**WELWYN HATFIELD BOROUGH COUNCIL  
EXECUTIVE DIRECTOR - PLANNING, PUBLIC PROTECTION AND GOVERNANCE**

**DELEGATED APPLICATION**

**Application No:** 6/2022/0922/FULL  
**Location:** 11 Tolmers Gardens Cuffley Potters Bar Hertfordshire EN6 4JE  
**Proposal:** Conversion and extension to existing single dwelling house to create 4x 1 bed apartments with associated infrastructure  
**Officer:** Ms Kirsty Shirley

**Recommendation:** Refused

21005_PL(20)003

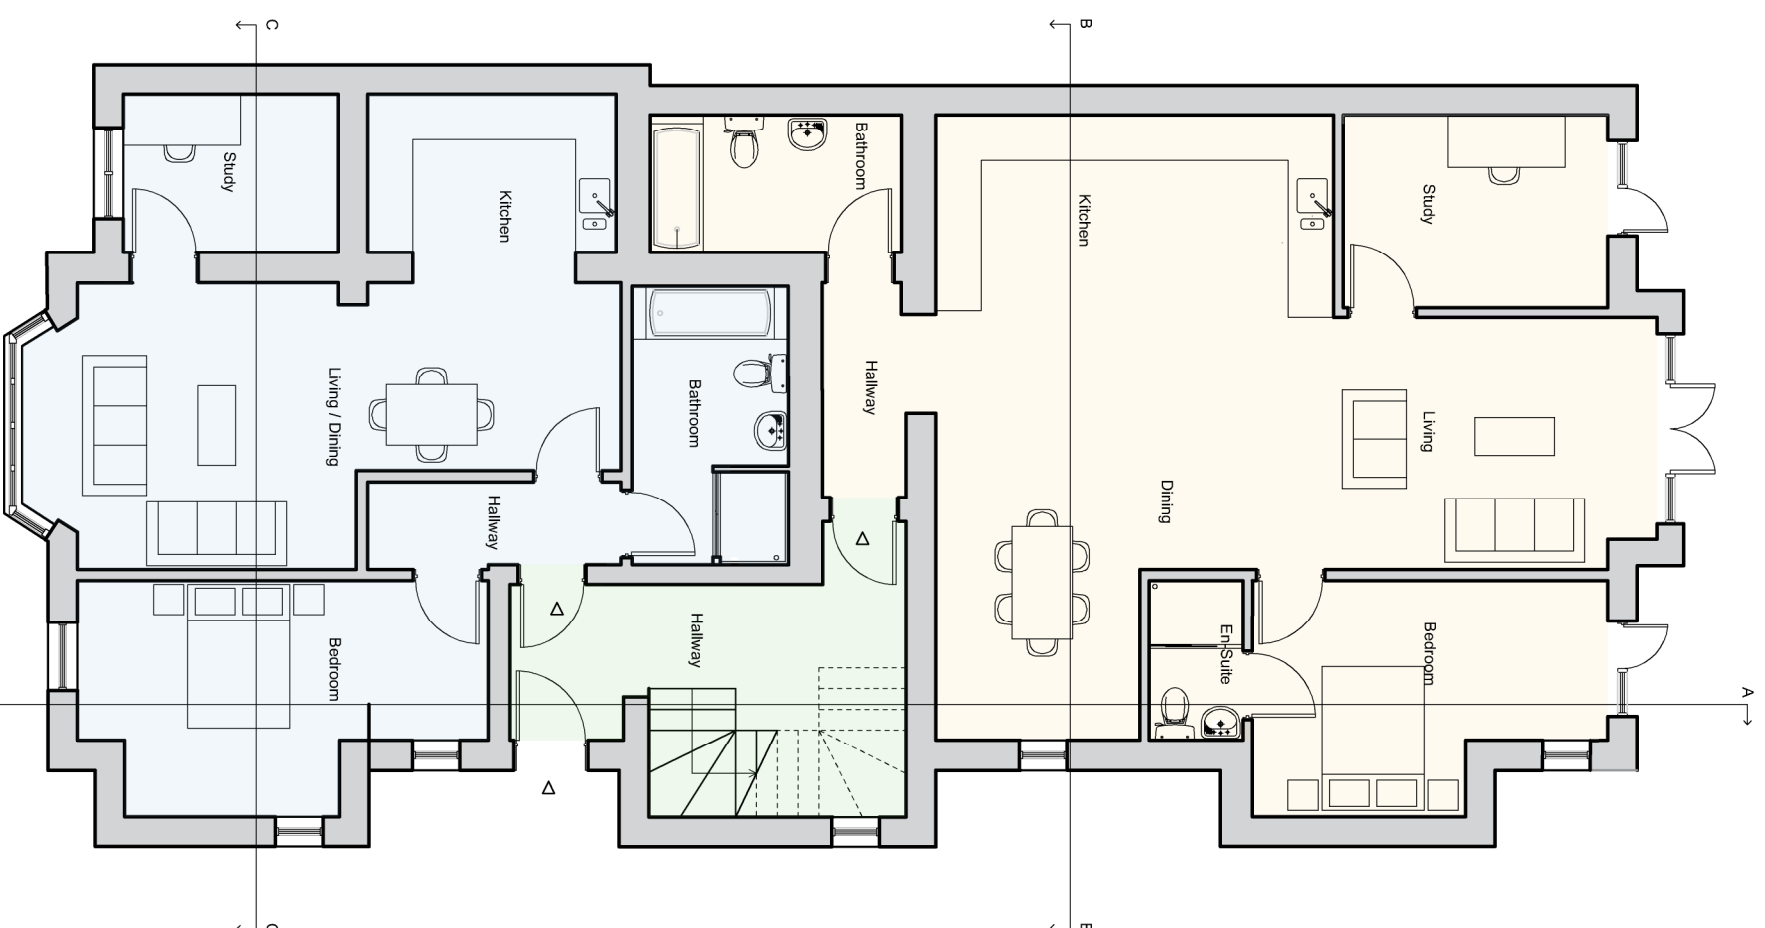
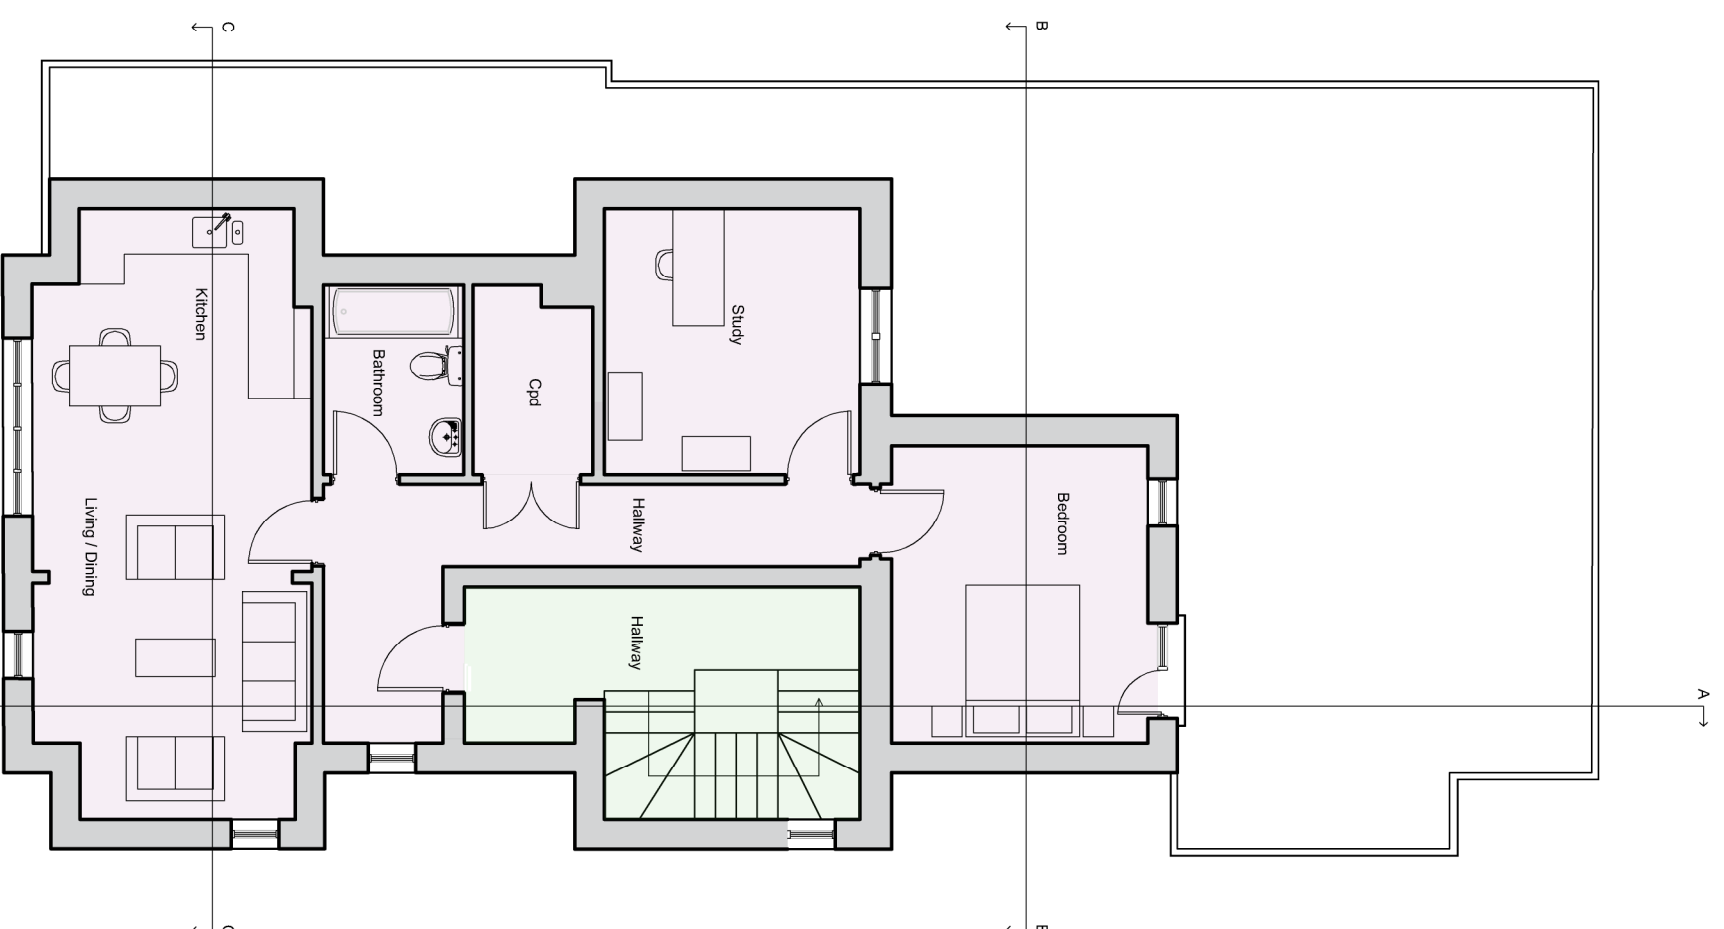
The proposed development would increase the size and scale of the existing dwelling on all floors, and notably at ground floor level due to a proposed single storey side to rear extension. The extensions at the ground floor level would project alongside the boundary line with No. 9 and intermittently project towards the boundary line with No. 12, with the extension then projecting towards the rear of the site. The existing garage would be converted to a habitable space and the side extensions would be setback from the front elevation, with the width of the front elevation remaining. The rear extension would occupy almost the entirety of the current rear garden serving the dwelling within the site. At first floor level, there would be a partial rear extension which would extend across approximately two thirds of first floor rear elevation, with intermittent projections at first floor level extending from either side of the dwelling, which would be repeated at the second floor level. There would be no increase in roof height, however the roof form would be altered.

The majority of dwellings in this area maintain at least a 1m separation distance above ground floor level. The proposed development would result in a lack of relief between the proposed building and adjoining neighbours, significantly reducing the space around the dwelling and appearing cramped compared to surrounding development.

By virtue of the site layout and relationship with adjoining premises, the bulk and mass of the proposed building, in particular the proposed depth and width of the building, would be visible and harmful to the character of the area and would appear cramped and contrived within the site.

2. The proposed conversion of the building to form four residential flats, by virtue of inadequate and insufficient amenity space provision for both existing occupiers of No. 12 and future occupiers of the proposed development, would represent unsatisfactory living accommodation for the future occupants. Accordingly, the development would be of a poor standard of design, failing to take the opportunities to function well and add to the overall quality of the area, contrary to Policies D1 and H4 of the District Plan; Policies SP9 and SADM11 of the Emerging Local Plan; Supplementary Design Guidance; and the National Planning Policy Framework.

DRAWING No.
21005_PL(20)004

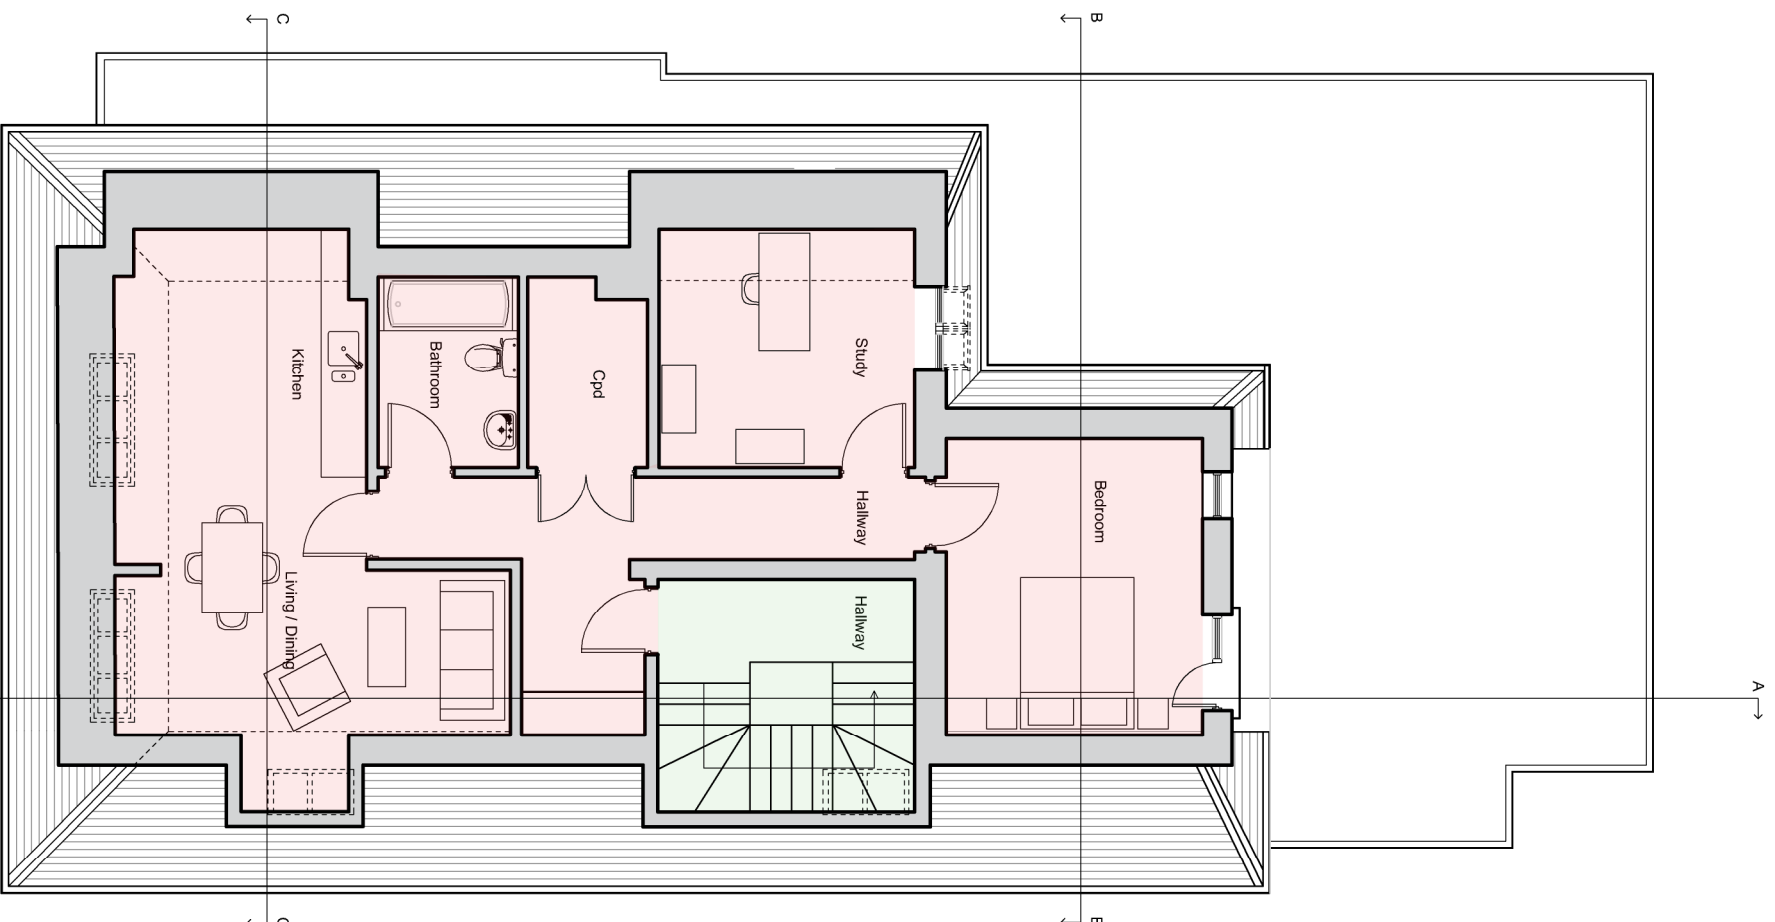
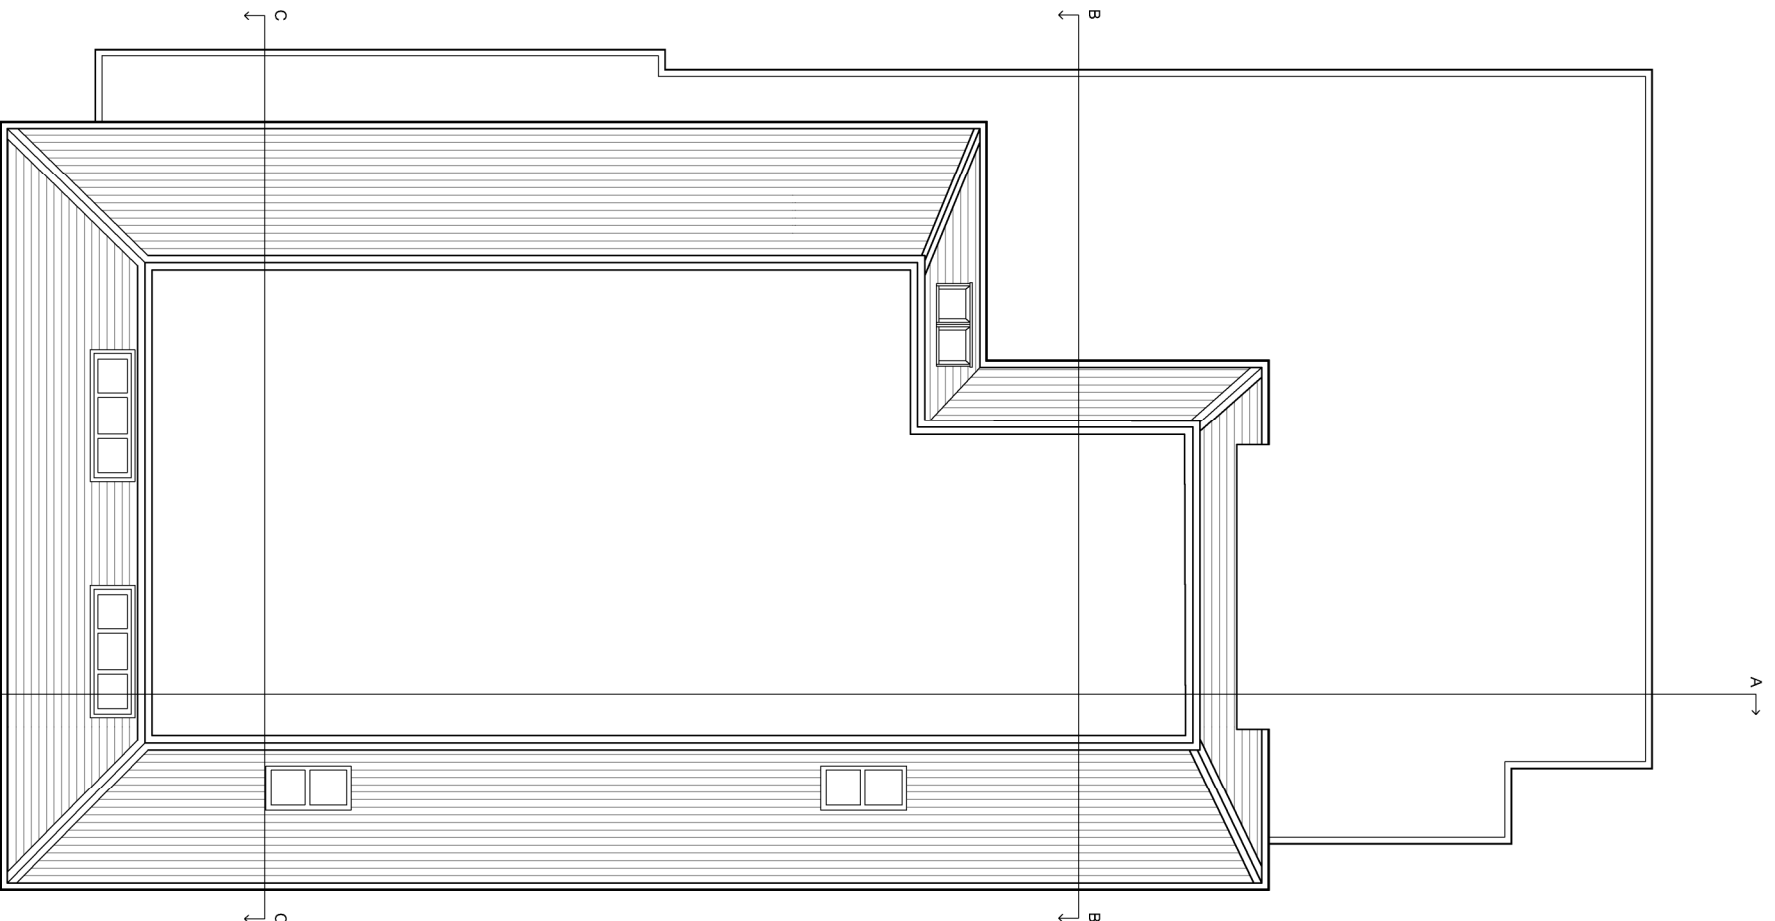
The existing dwelling features a hipped roof and the proposal would introduce

|  | <p>a mansard roof form, which is not characteristic or featured predominantly in the area. The design and style of the mansard roof would add significant bulk at the roof level, substantially increasing the massing at ridge height. The eaves of the proposed mansard roof would project outwards from the front flank elevations of the dwelling, and the roof would be approximately a third of the height of the dwelling. The form, size and scale of the proposed roof would result in the roof to appear overbearing and top heavy towards the application building, detracting from the appearance of both the building and wider area.</p> <p>Furthermore, the degree of pitch at the front roofslope would differ from that of the rear pitch. Due to the partial first floor rear extension, there are two rear roofslopes which would not match one another or the front roofslope in terms of pitch degree. The rear roofslope of the proposed partial first floor extension would feature a cut out to allow for a Juliet balcony and window to serve the second floor. The cut out would be square in shape, and the flank roofslopes of this part of the roof would have further differences in degree pitch. Such differing degrees of pitch across the roofslope would result in an incongruous and mismatched roof, and subsequently represent poor design.</p> <p>Consequently, it is therefore considered that the design of the proposed building, in terms of scale, size, massing, bulk and style would appear as an incongruous and discordant building within the street scene. Accordingly, the proposal is considered to be in conflict with District Plan Policies D1 and D2; Policy SP9 of the Emerging Local Plan; the Supplementary Design Guidance; and the National Planning Policy Framework.</p>   |

21005_PL(25)003

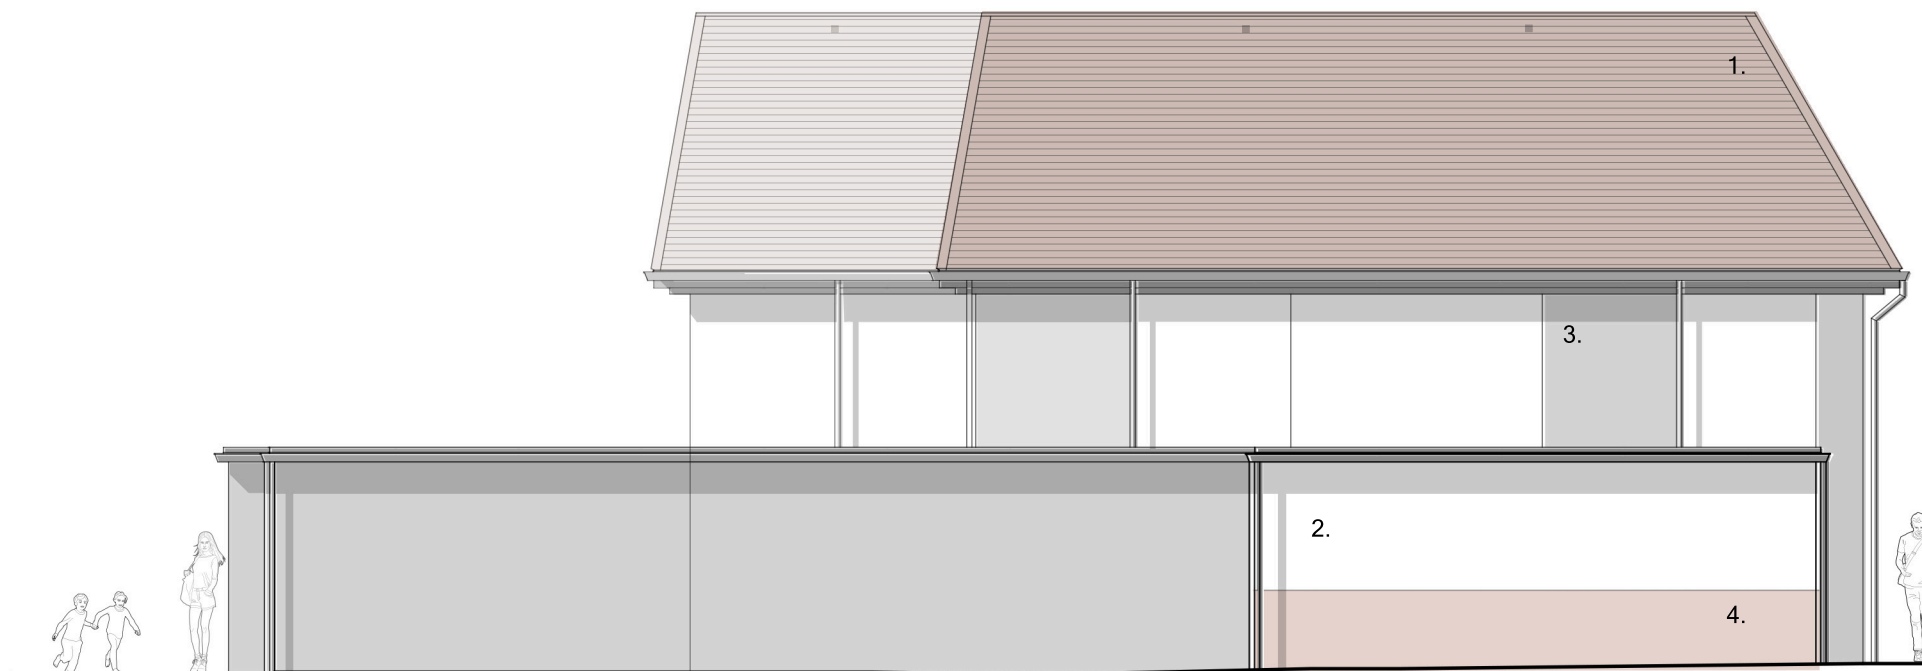
1. The design of the proposed building, in terms of scale, size, massing, bulk and style would appear as an incongruous and discordant building within the street scene. Accordingly, the proposal is considered to be in conflict with District Plan Policies D1 and D2; Policy SP9 of the Emerging Local Plan; the Supplementary Design Guidance; and the National Planning Policy Framework.

21005_PL(25)004

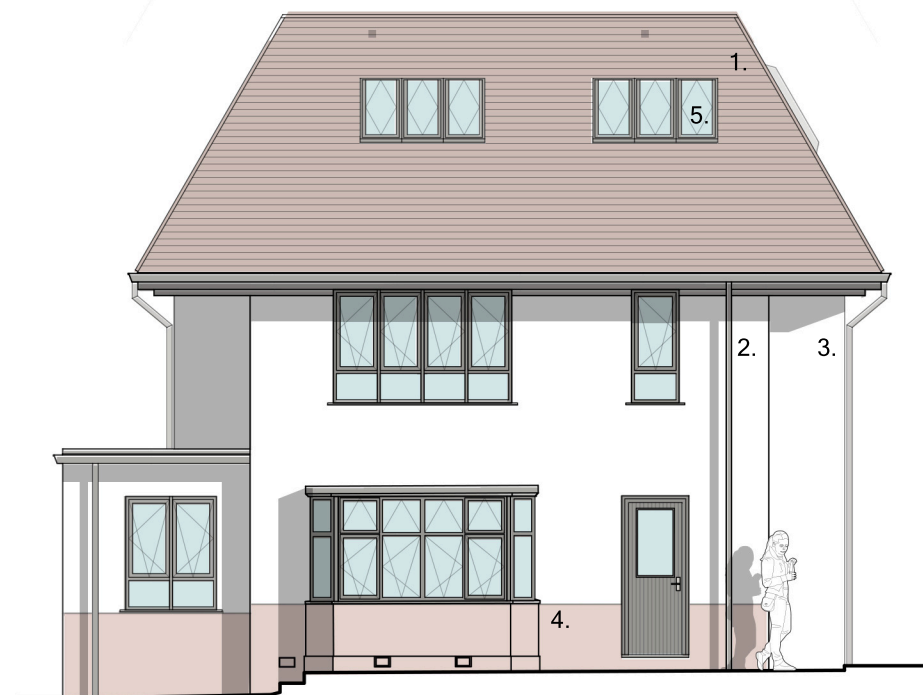
|  | <p>sloping, resulting in the application site to be situated on higher ground than No. 9 and exacerbating the height and scale of the rear extension towards No.9. The position and scale of the proposed rear extension of the development would therefore result in the most useable part of No. 9's garden to become overshadowed much earlier in the day, resulting in these occupiers to experience a detrimental loss of light.</p> <p>The development would therefore be in conflict with District Plan Policy D1; Policies SP9 and SADM11 of the Emerging Local Plan; the Supplementary Design Guidance; and the National Planning Policy Framework.</p>  |

3. The proposed development would result in the most useable part of No. 9's garden to become overshadowed much earlier in the day, resulting in these occupiers to experience a detrimental loss of light, contrary to District Plan Policy D1; Policies SP9 and SADM11 of the Emerging Local Plan; the Supplementary Design Guidance; and the National Planning Policy Framework.
